From: Martin Hill <Martin.Hill@arun.gov.uk>
Sent: 19 May 2021 10:17
To: Planning.Responses <Planning.Responses@arun.gov.uk>
Subject: RE: Planning Consultation on: AW/130/21/PL

Application No: AW/130/21/PL

Site Address: 10 Robins Drive Aldwick PO21 3BL

Description of Works: Part change of use of attached annexe from residential to rent for unrelated people. This site is in CIL Zone 4 (Zero Rated) as other development.

PLAN WITH WITH ANY ALTERATIONS NECESSARY TO CONVERT TO ANNEX

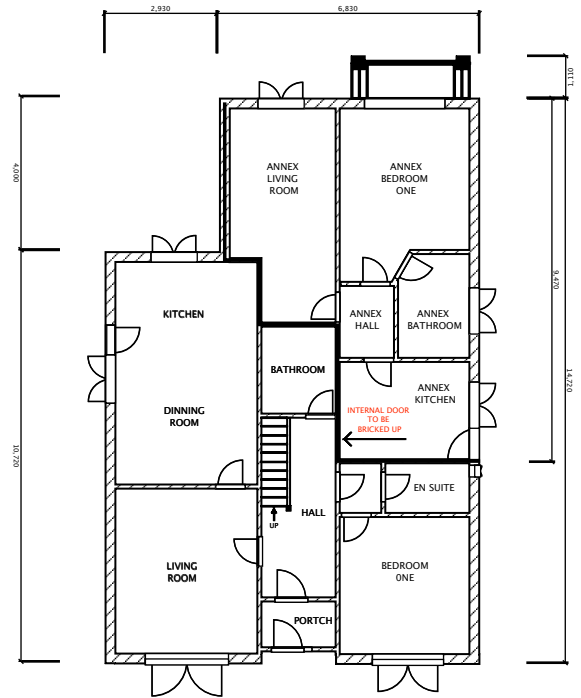
- A room where the only escape route is through another room is termed an “inner room” and poses a risk to its occupiers if a fire starts unnoticed in the outer room. The escape route from the Annexe living room and Annexe bedroom appears to be via the kitchen, which would be unacceptable as the sole means of escape. This can be overcome by ensuring that the windows in the Annexe living room and Annexe bedroom meet the requirements of escape windows. An externally opening door with a thumb turn device fitted is advisable to provide for a suitable secondary means of escape from the lounge or bedroom and where these doors are made available, this in turn will mean the lounge and bedroom areas (where fitted) would no longer be classified as inner rooms. Where escape windows are fitted, care must be taken to ensure they are of adequate size, they open to level and unobstructed areas and lead to a place of ultimate safety. It is difficult to ascertain if there would be an obstruction outside of the Annexe bedroom and this must be considered when escape windows or doors are fitted. Further guidance can be found in the LACoRS housing fire safety guidance.

Where an externally opening door with thumb turn device is not available to the inner room, a fire door conforming to FD30S standard must also be installed between the inner and outer rooms.

- There should be adequate fire separation between the main house and the Annexe. This should be 60 minutes fire resistance horizontally and vertically. If this cannot be achieved,

- Grade D, LD2 fire alarm and detection system,
 - o interlinked mains wired smoke alarms with integral battery back-up located in the Annexe Hall and in the Annexe Living RoomIt is also recommended to install an interlinked heat alarm with integral battery back-up in the Annexe kitchen

Annexe – Annexe kitchen door and any secondary door fitted in accordance with the inner room requirements, as set out above.
